From: Anita Gardner <Anita.Gardner@arun.gov.uk>
Sent: 08 December 2020 08:48
To: Planning.Responses <Planning.Responses@arun.gov.uk>
Subject: FW: Objection to Planning Application - AB/114/20/PD

Objection to Planning Application
AB/114/20/PD
Riverside House
2 Fitzalan Road
Arundel

BN18 9JS

Drawing Title:
PROPOSED ELEVATIONS

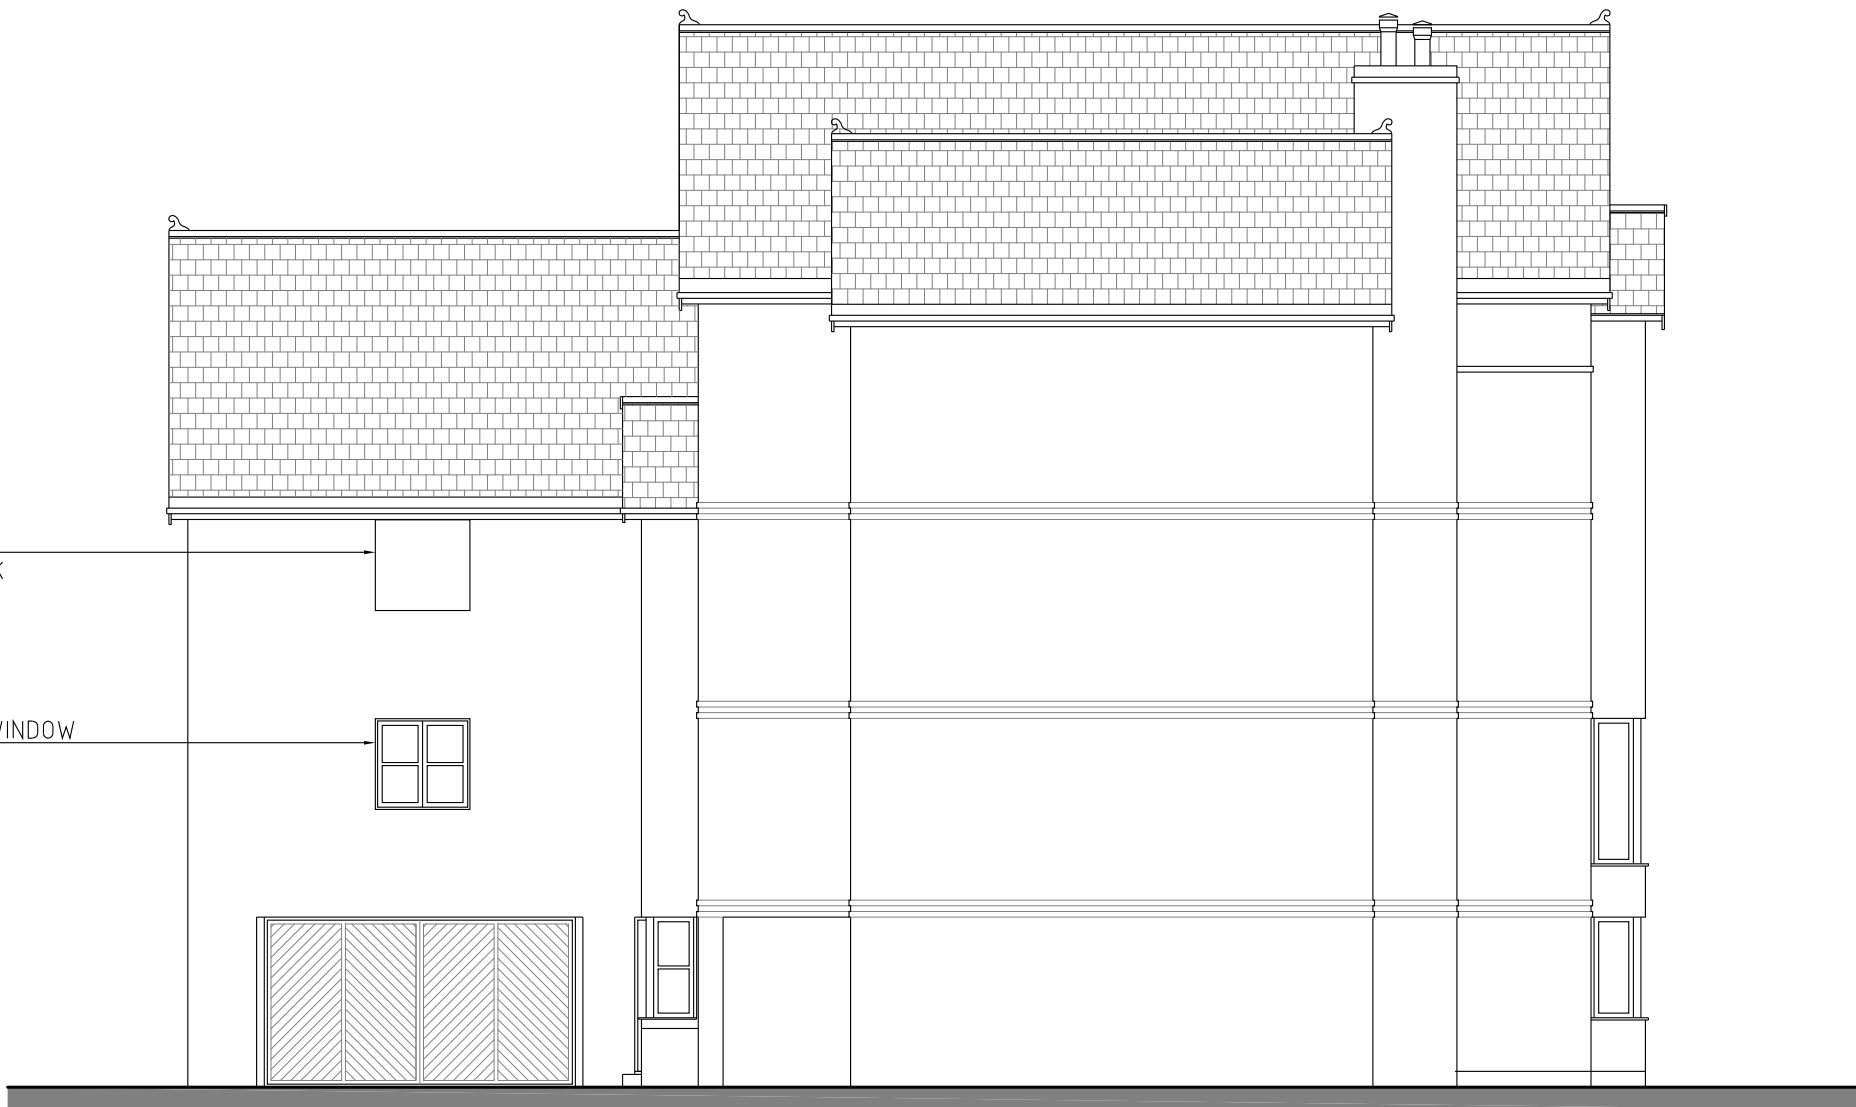
1. The proposed increase of two additional floors considerably raises the elevation, nearing the height of the Martlets Court building which in itself breached planning regulations when it was built. The relative height of Martlets should not therefore be used as a justification to increase the height of other buildings in the vicinity which is essentially a low-rise residential area.

2. The benchmark for new buildings should respect the other 2-story buildings of Fitzalan Road in keeping with the streetscape, or we set a dangerous precedent by gradually increasing building height along the east bank of the Arun.

3. The proposed elevation will obscure the view into and out of the Arundel Conservation Area, much to its detriment.
4. I note from the plans that there are some eleven proposed bathrooms, the future intent for which is surely a multi-occupancy dwelling of several flats. If this is indeed the case it should be declared as such, and not become an example of incremental development by stealth. If the intent is for a multi-occupancy building then parking requirements should be appropriately scaled, and the increase in traffic taken into consideration at this stage of the planning application.
